CITY OF ALBUQUERQUE

**RE: La Vista Subdivision - Lot 9C
Grading and Drainage Plan
Engineer's Stamp Date 8-1-2016 (File: C19D042B)**

Based upon the information received on 9-19-2016, the above-referenced Grading and Drainage Plan is approved for Building Permit.

LA VISTA AT DESERT RIDGE
LOT 9C
GRADING AND DRAINAGE PLAN

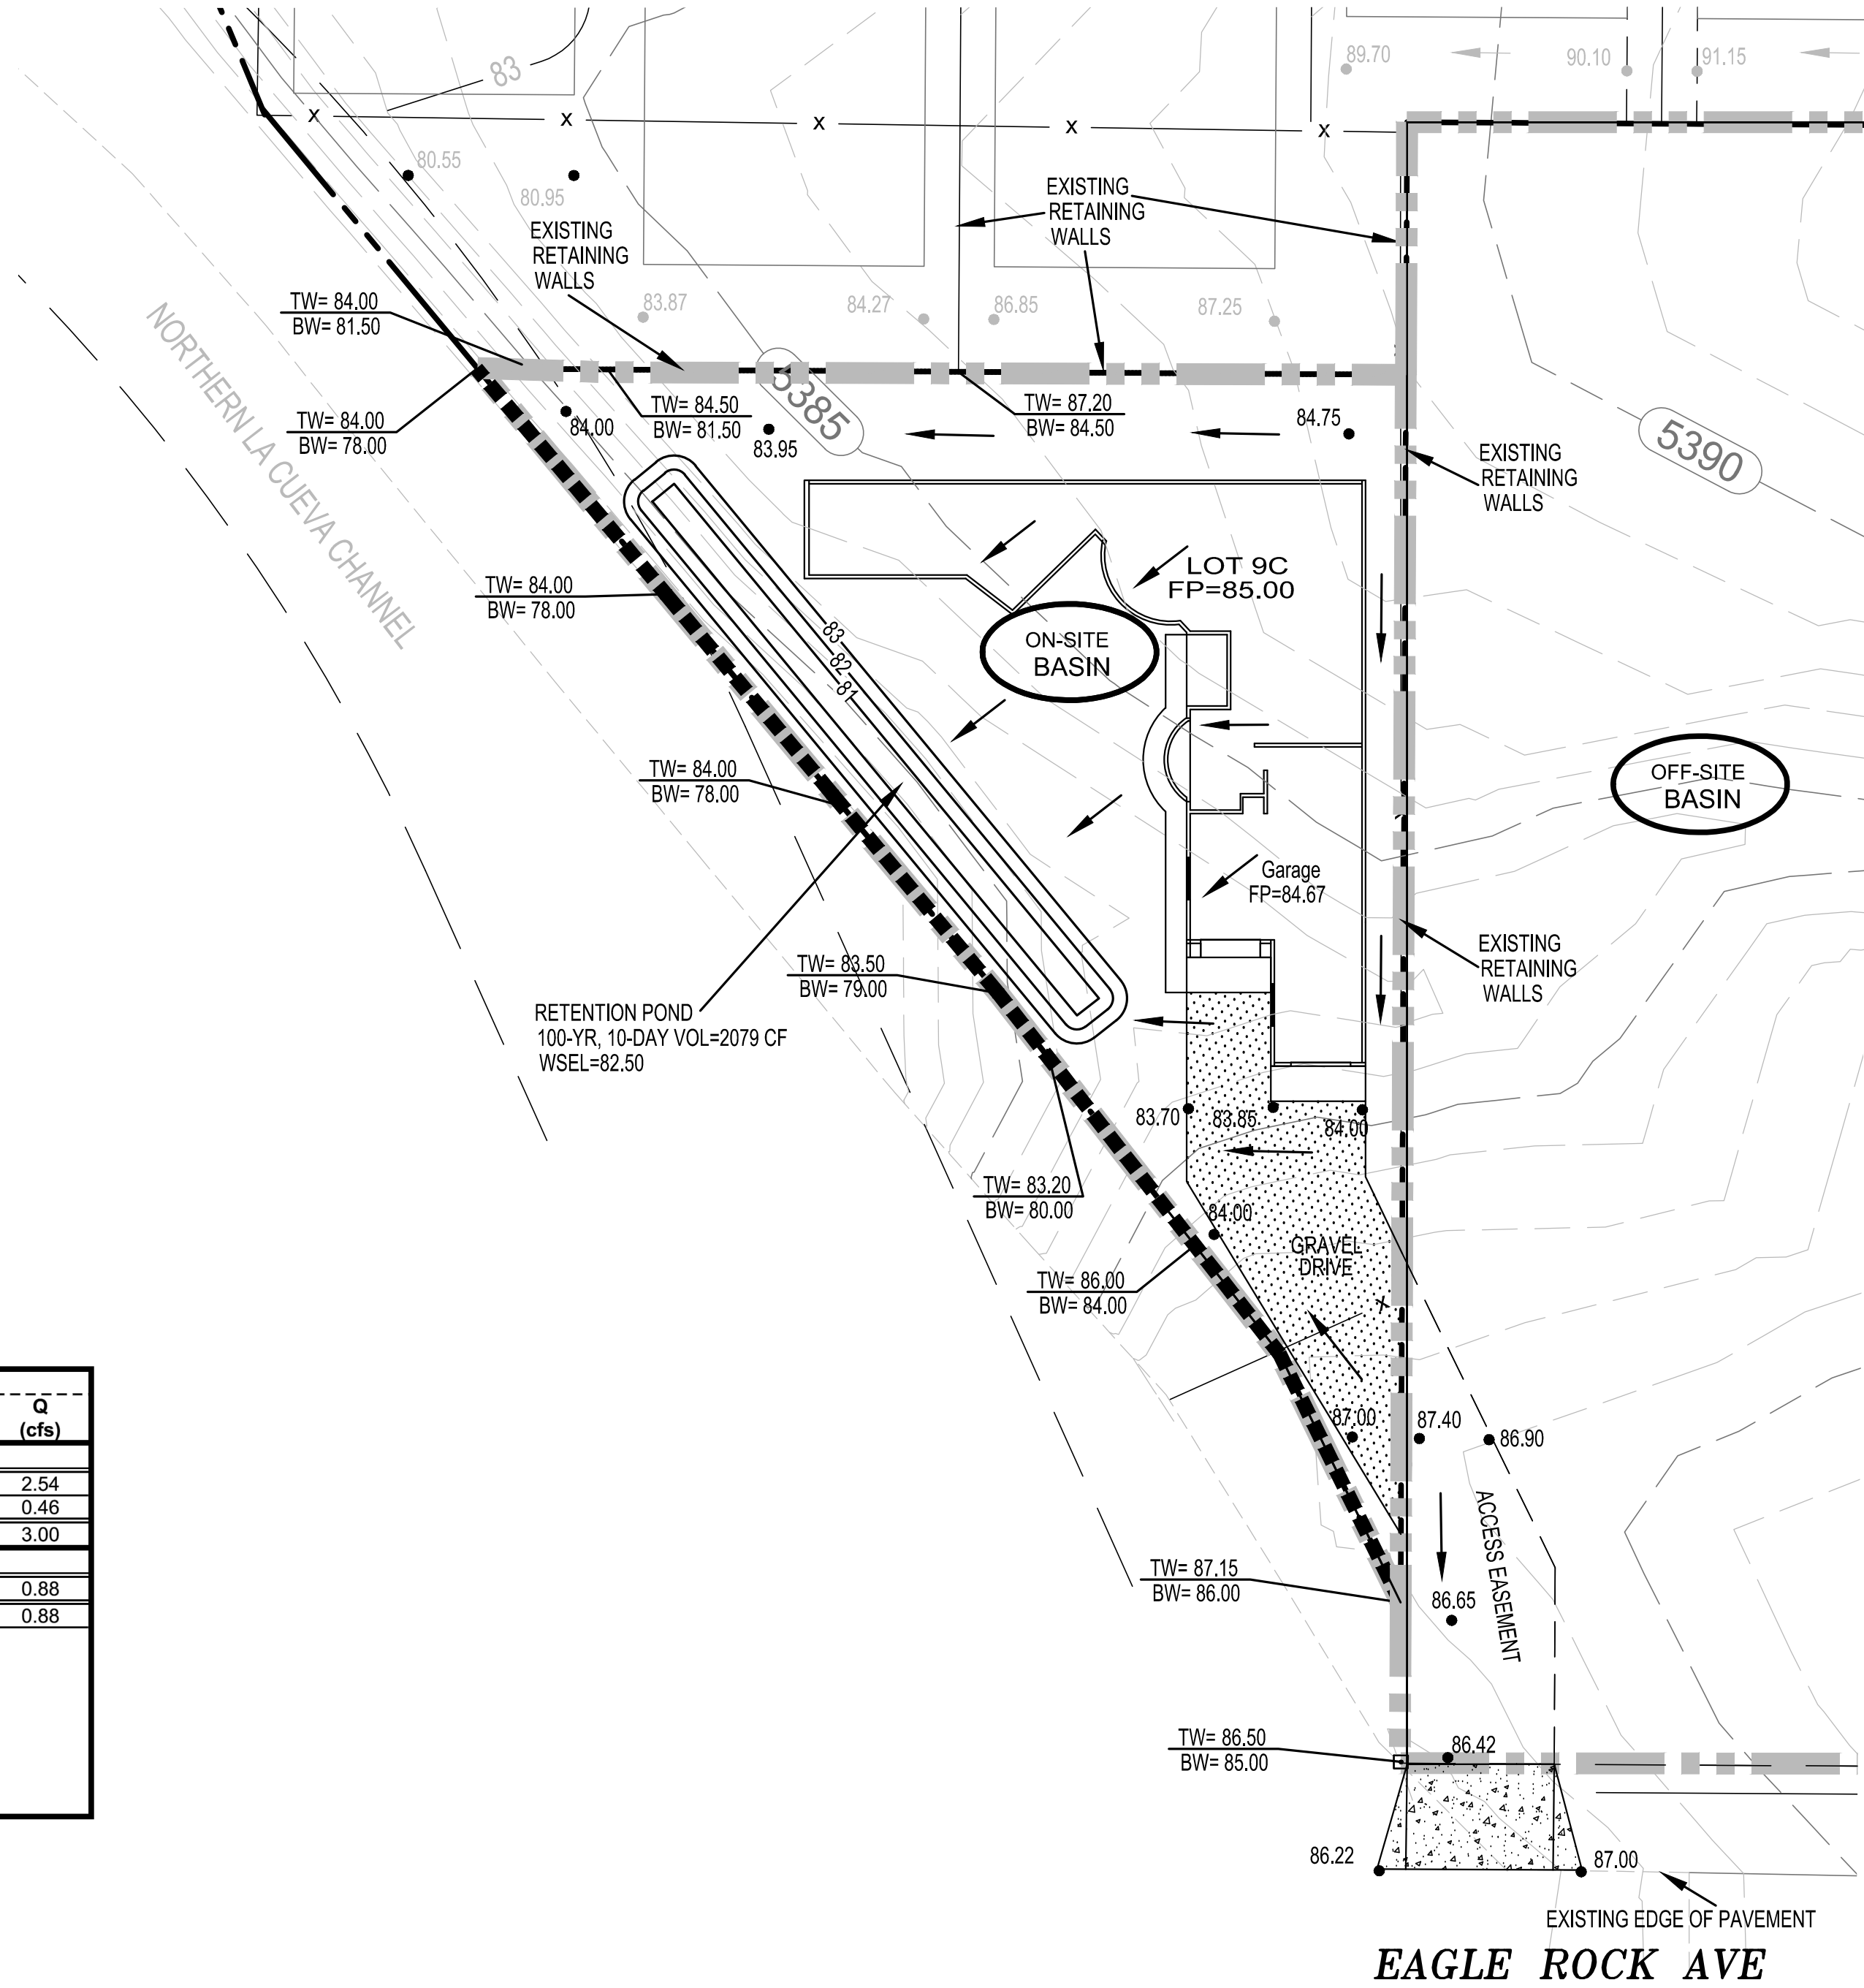
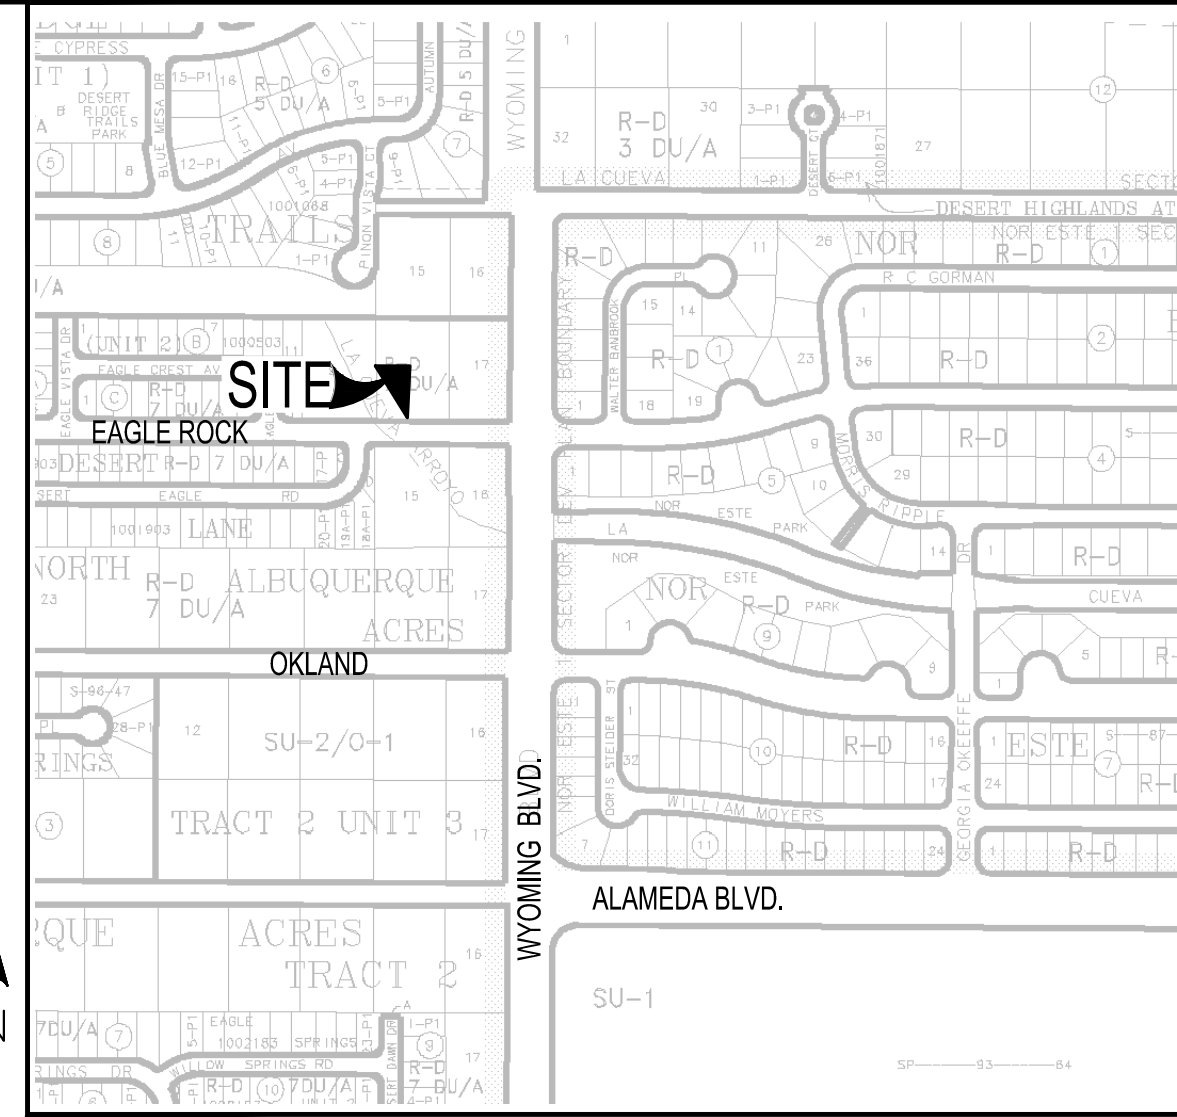
- It is understood that the shape of the first flush pond might be decided in the field with the landscaping contractor. However, please show the approximate location (and shape if known) of the pond for verification of the approximate volume for Certificate of Occupancy, since the spot elevations don't suggest that there is a pond to be graded.

- The outfall into the La Cueva Channel needs to be approved by AMAFCA. We do recommend, however, that the rundown is made of concrete because it appears that it will be in the path of AMAFCA's access to the channel.

- The retaining wall to the west is proposed with an L-Shape footing, which can be difficult to achieve with 6'+ heights. Its design should be stamped by a structural engineer.

- The driveway should have a flare, at least along the east edge (triangular or curved). Otherwise, a pothole and nuisance ponding are expected to develop at the corner.
